# RFS

Your reference: SSD-67478479  
Our reference: DA20240209000558-EIS & DA Exhibition-1

**State Significant Development – Electricity Generating Works**  
**Request for comments – exhibited Environmental Impact Statement (EIS)**  
**Yanco BESS - 120 HOUGHTON RD YANCO NSW 2703, 516//DP751745**

Landscape Concept Plan

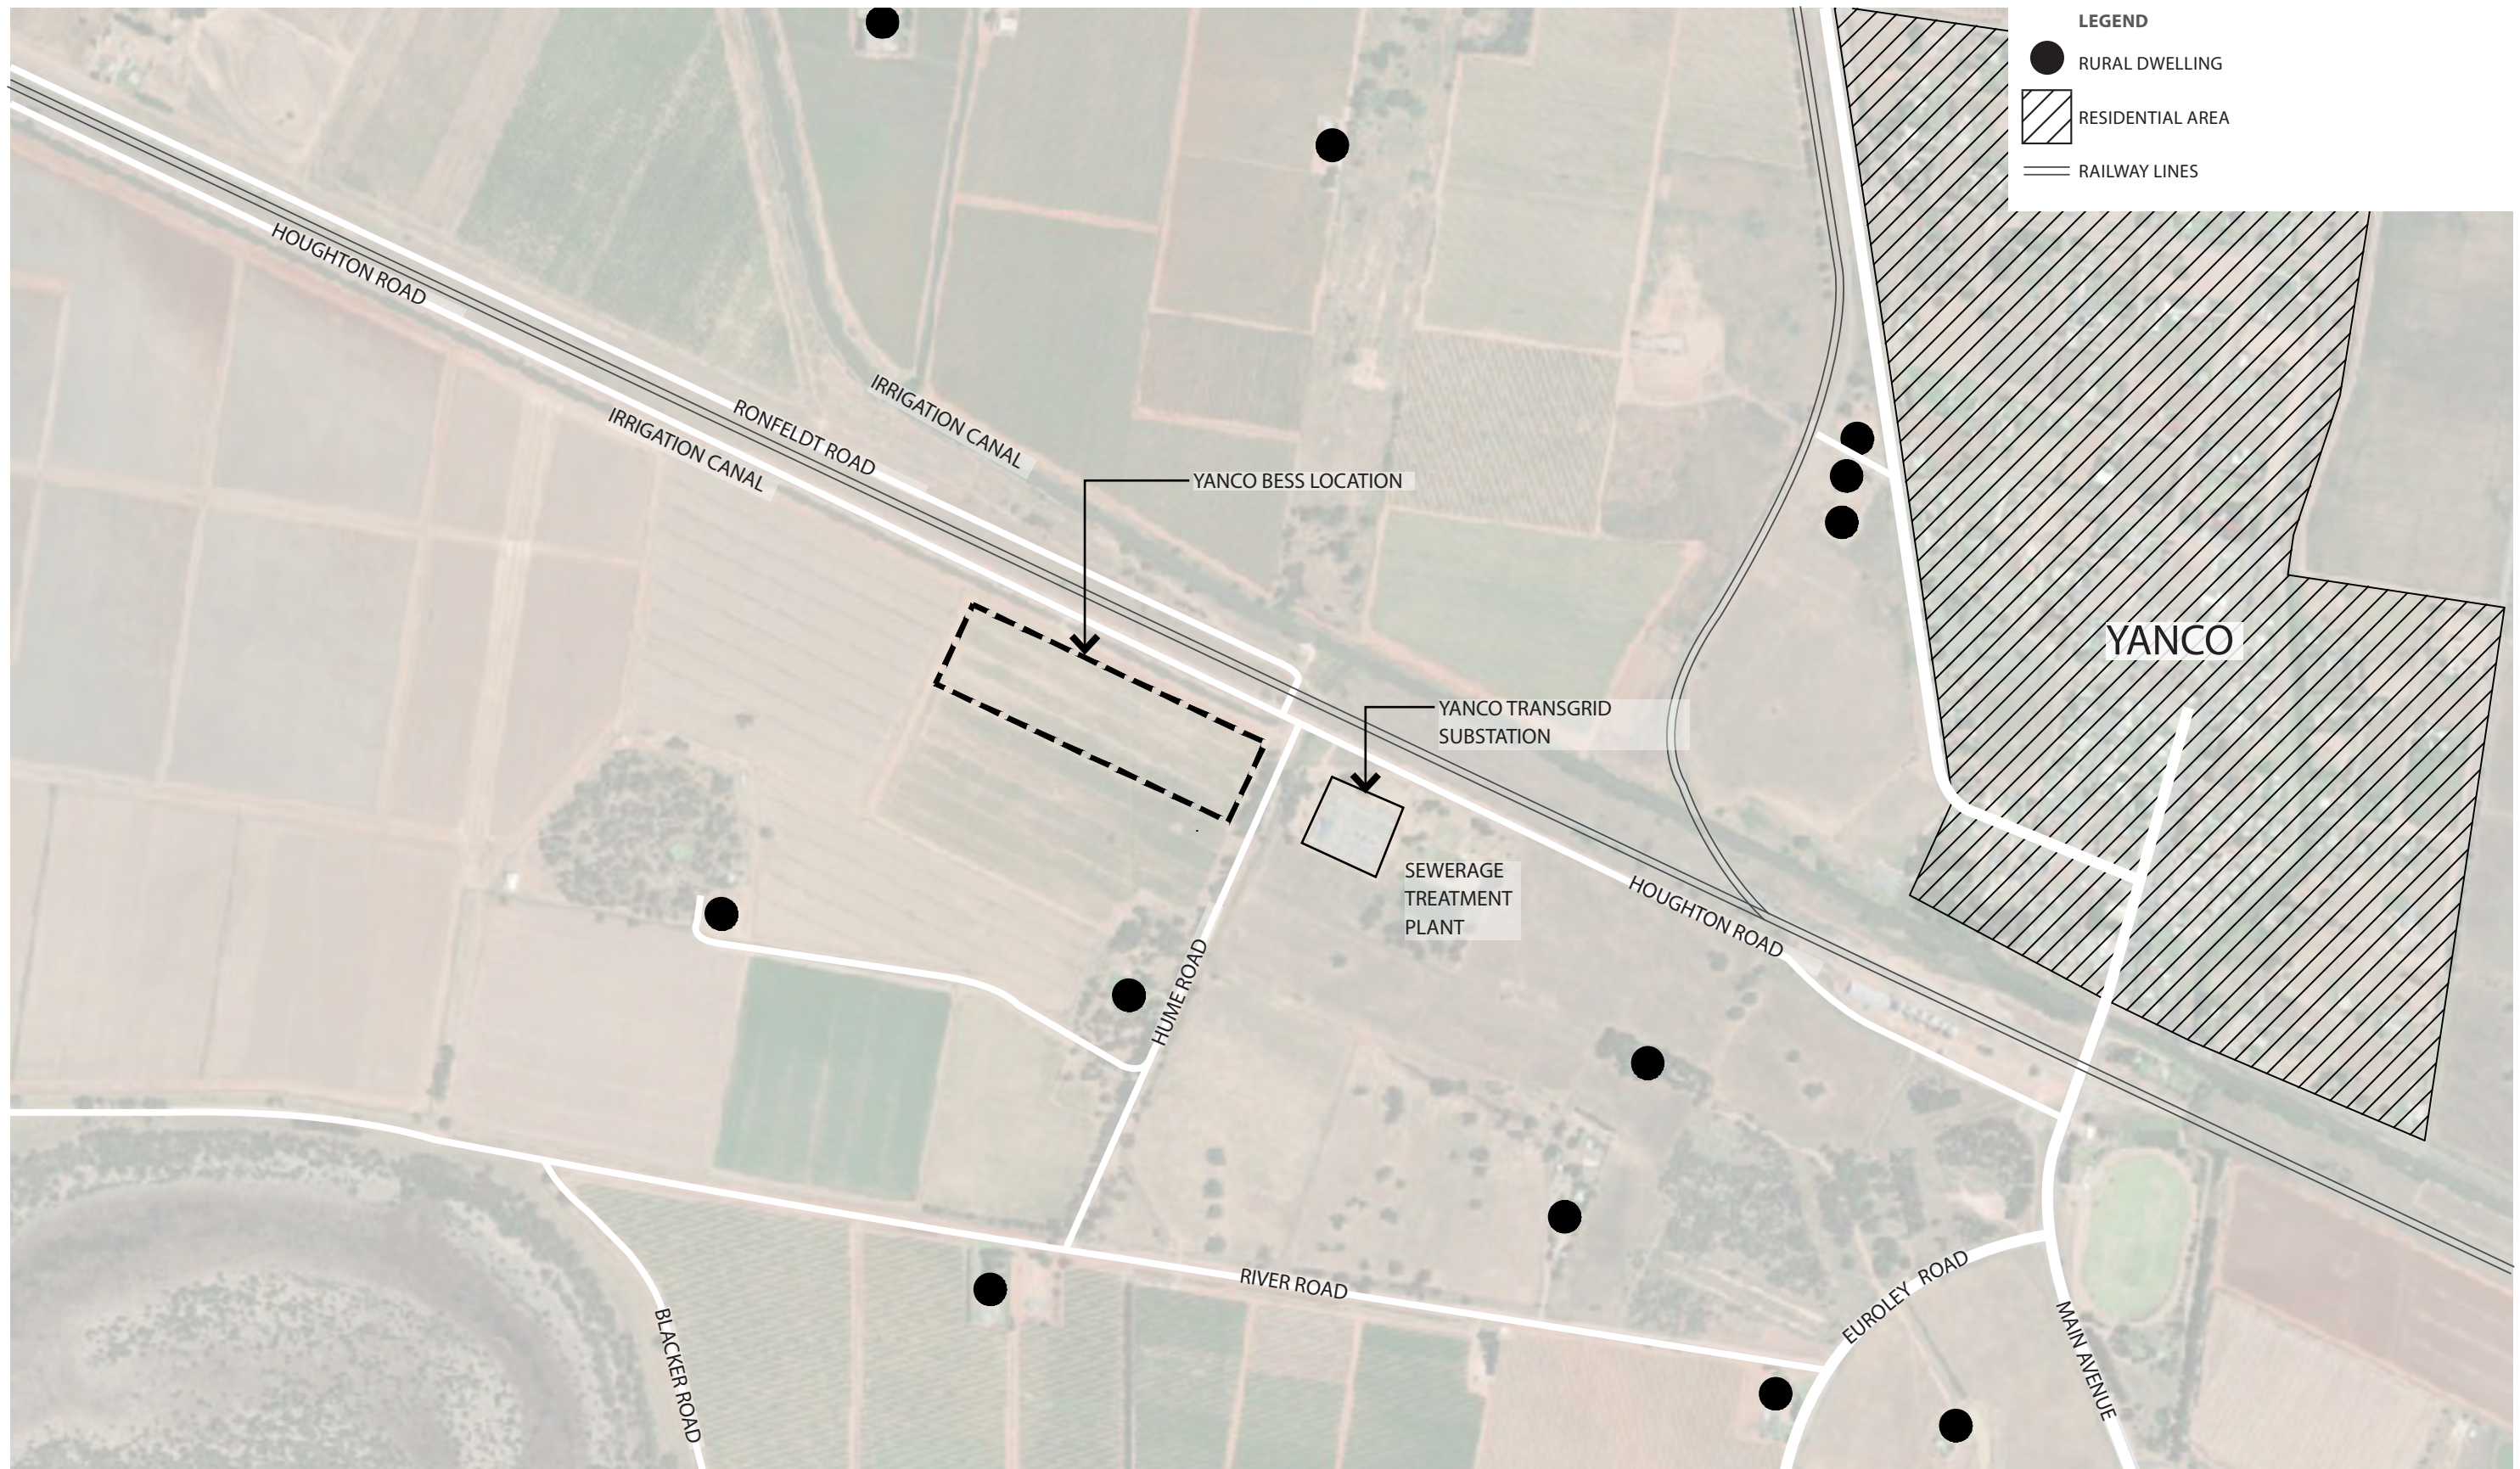
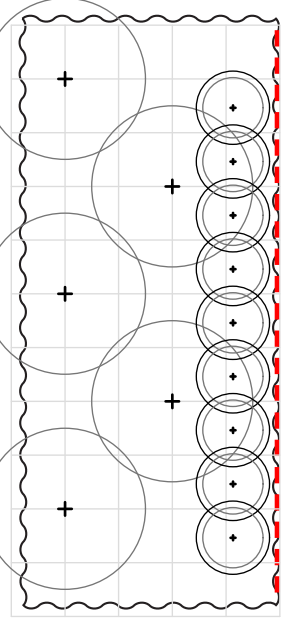
Additionally, any future approval should require the design and maintenance of the screen planting to be generally consistent with the Landscape Concept Plan (issue E, dated 19.09.24). The following items should be addressed in the design of the plantings and in the Bushfire and Emergency Management Operation Plan;

- Avoid species with rough fibrous bark, or which retain/shed bark in long strips or retain dead material in their canopies;
- Use smooth bark species of trees species which generally do not carry a fire up the bark into the crown;
- lower limbs should be removed up to a height of 1 m above the ground;
- grass should be kept mown (as a guide, grass should be kept to no more than 100mm in height); and
- leaves and vegetation debris should be removed regularly.
